6. Utilities

Attn: William Savage
Re: 31 Fore Street - Portland
Ability to Serve with PWD Water

Rw: Wastewater Capacity Application Approval for Wastewater Flows from 31 Fore Street – Multi-Family Housing

DRAWING NO.
C-20

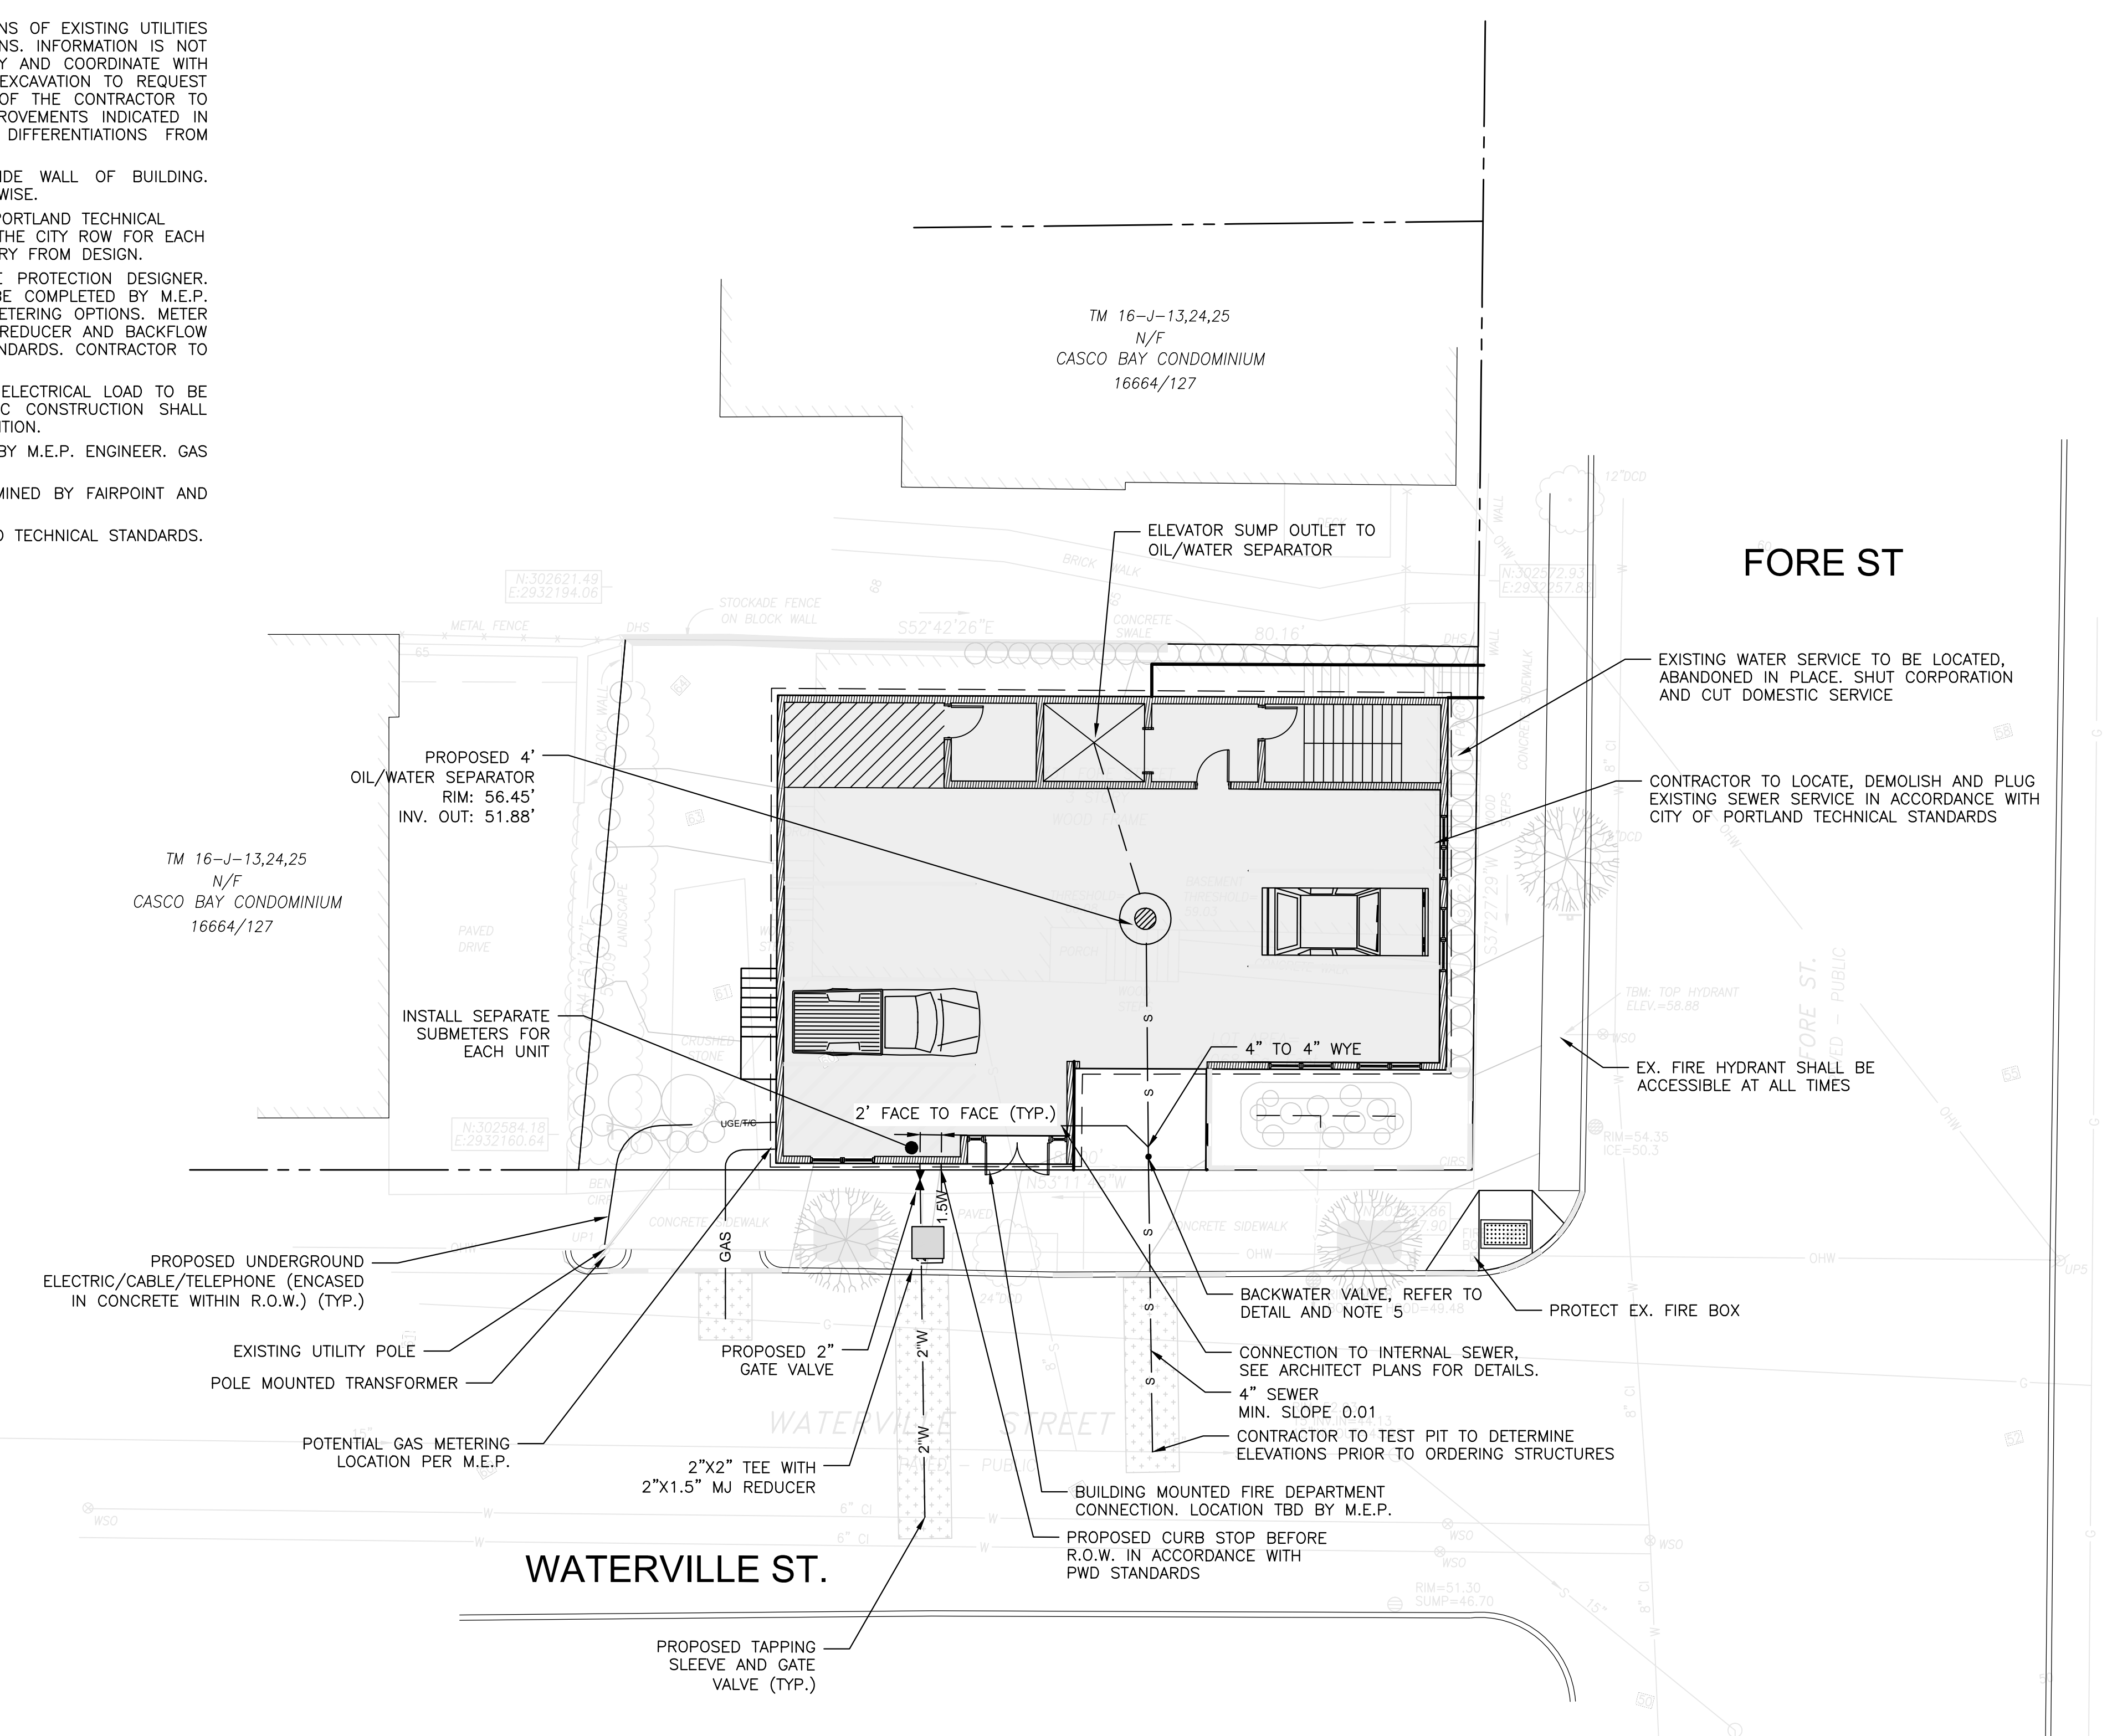
- The configuration shown on the plans is suitable where a single building owner/tenant organization is the customer of record, the sizing is not adequate however. Please provide the anticipated fire and domestic demands in order to ensure proper sizing. Memo metering (submeters called out on plans) would be private and the responsibility of the customer of record. If individual billing is desired, individual services at the streetline would be required (with separate curbstops). The sprinkler service would remain billed to the building owner/tenant organization.

- The Utility Layout Plan shows a single tap into the water main with a manifold at the street line, this is an acceptable configuration to the District; However, the sprinkler system designer should be consulted to confirm that the domestic demand (which we recommend increasing to a minimum of 1.5-inch) would not undermine the sprinkler service line sizing.
